PROJECT TITLE: TOTAL PETROLEUM, INC.
VICKERS GASOLINE ZONE ATLAS/DRNG. FILE #: J-13/1018
LEGAL DESCRIPTION: CONVENIENCE STORE & CARWASH
LOT 5-A-1, TRACTION PARK ADDITION
CITY ADDRESS: 2309 CENTRAL, NW, ALBUQUERQUE, NEW MEXICO

RE: DRAINAGE PLAN FOR THE VICKERS GASOLINE, CONVENIENCE STORE, &
CARWASH FACILITY, SUBMITTED JANUARY 31, 1989, FOR BUILDING
PERMIT (J-12/D13)

RE: GRADING & DRAINAGE PLAN FOR THE VICKERS GASOLINE, CONVENIENCE STORE,
AND CARWASH FACILITY, SUBMITTED JANUARY 31, 1989, FOR BUILDING
PERMIT (J-12/D13)

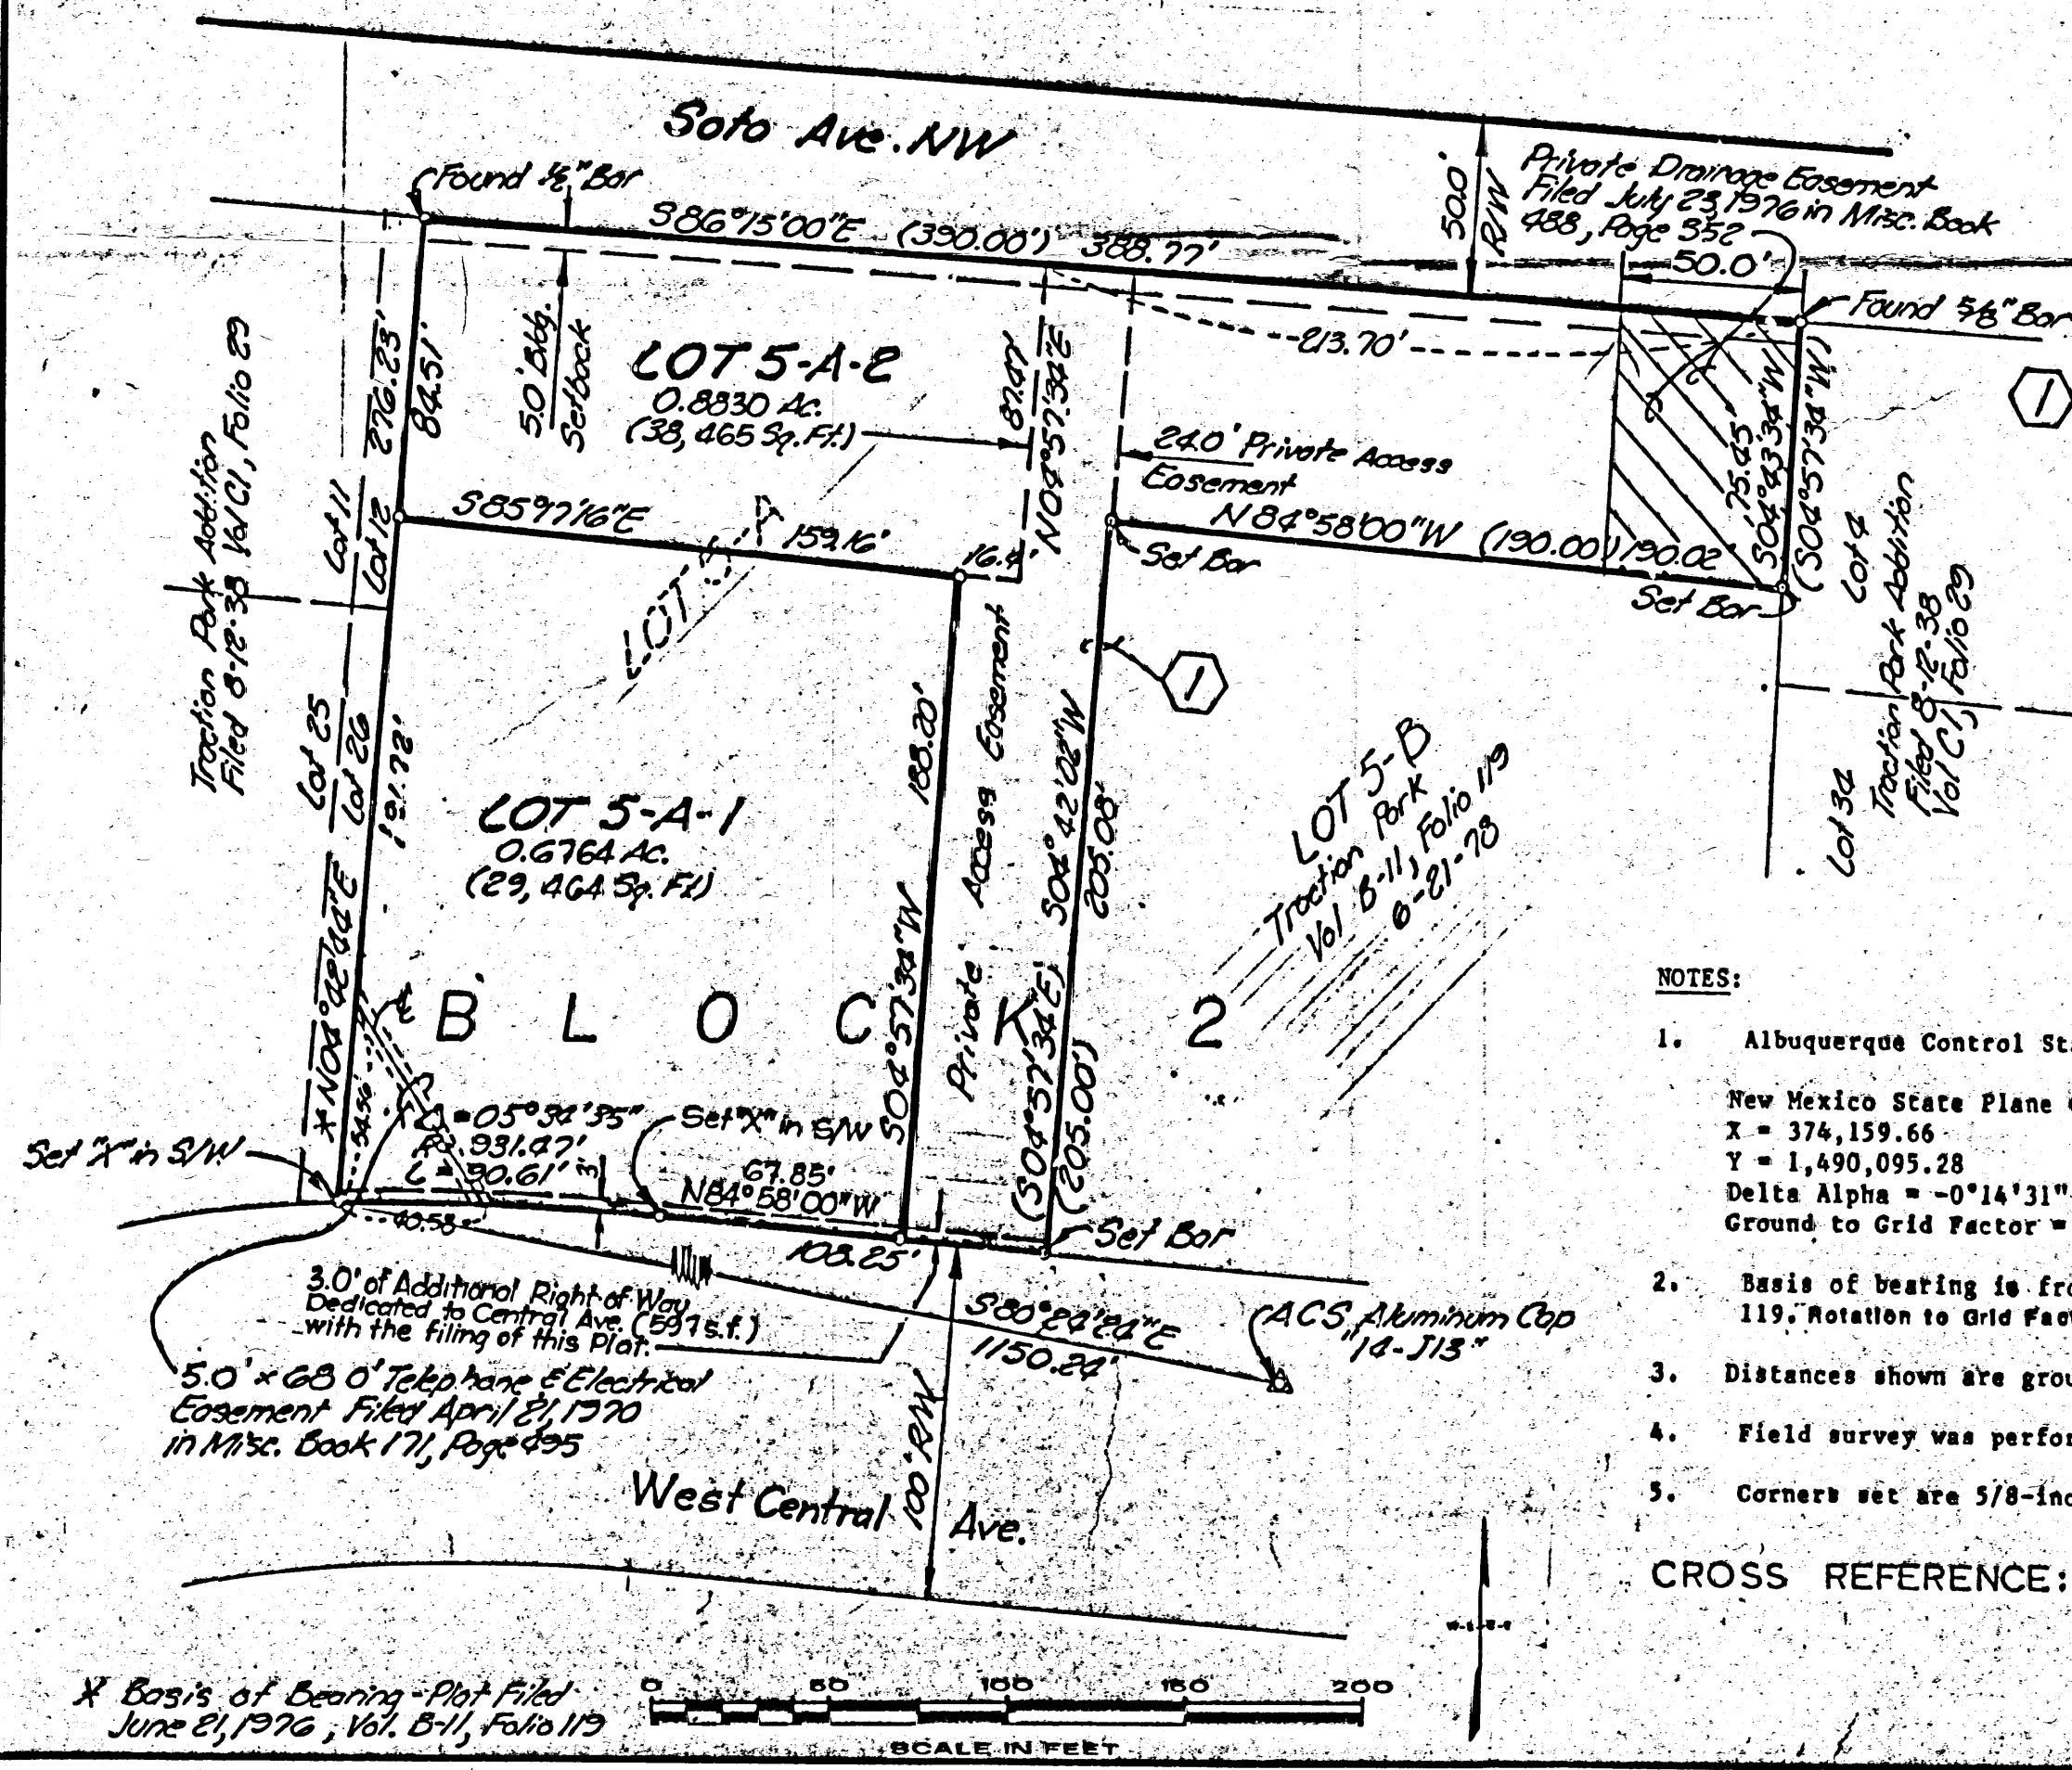
1. Finish floor elevations must be shown to full mean sea level designation.
2. Your existing and proposed spot elevations indicate that you will be draining developed runoff onto the 40' access easement. In order to allow cross lot line drainage, the easement must also indicate drainage easement. Please address.
